From: Sue Howell
Sent: 26 May 2016 14:47
To: Planning.Responses
Cc: Ross Leal
Subject: RE: Planning Consultation on: BN/19/16/PL

Comment from Greenspace

Site Address: Land at Pollards Nursery Lake Lane Barnham
PO22 0AF

Description of Works: Demolition of vacant office building & erection of
7 No. dwellings with associated garaging &
landscaping. This application is a Departure from
the Development Plan.

APAL FILE REFERENCE
2600-PP-06

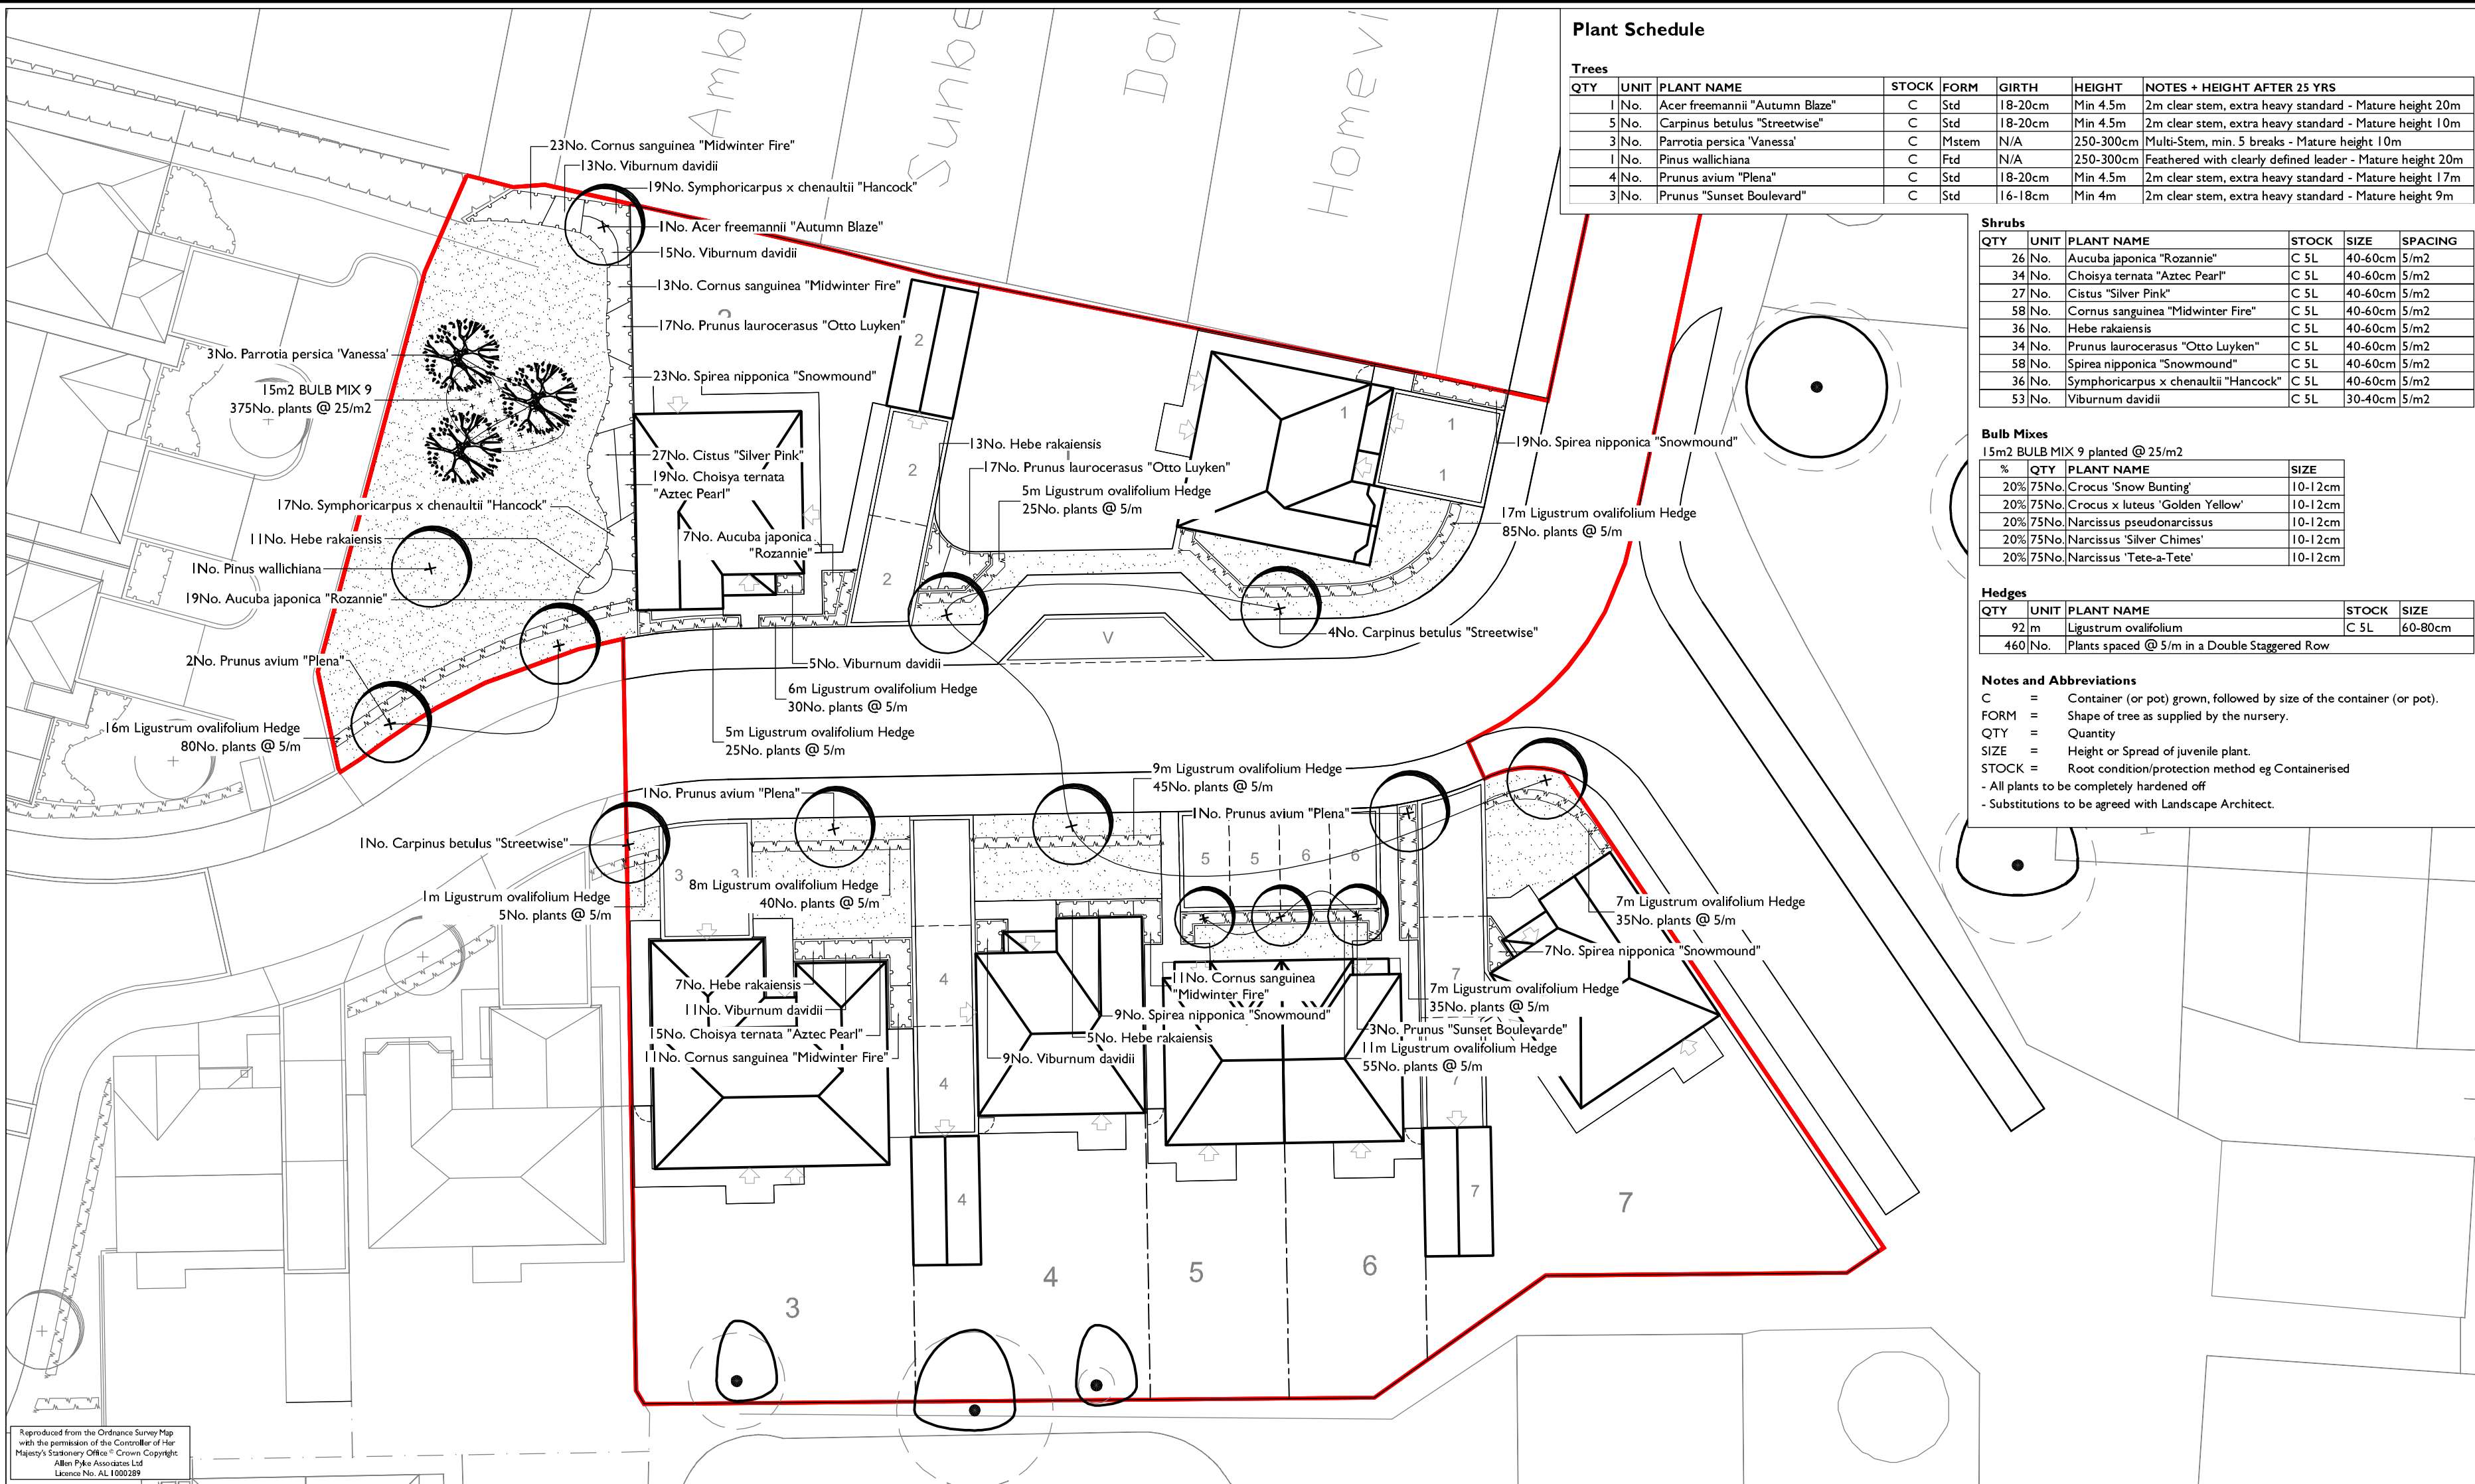
The details submitted under this application in relation to landscaping and the submission of Landscaping details dwg 260-LA-07 and Planting plan dwg 2600-PP-06, we confirm has detailed all information that would be requested by detailing a scheme of landscaping hard and soft. The proposed scheme details species choice which is suitable for location.

We are satisfied that the information received is sufficient and would recommend that we would have no objection to the landscaping proposals submitted.
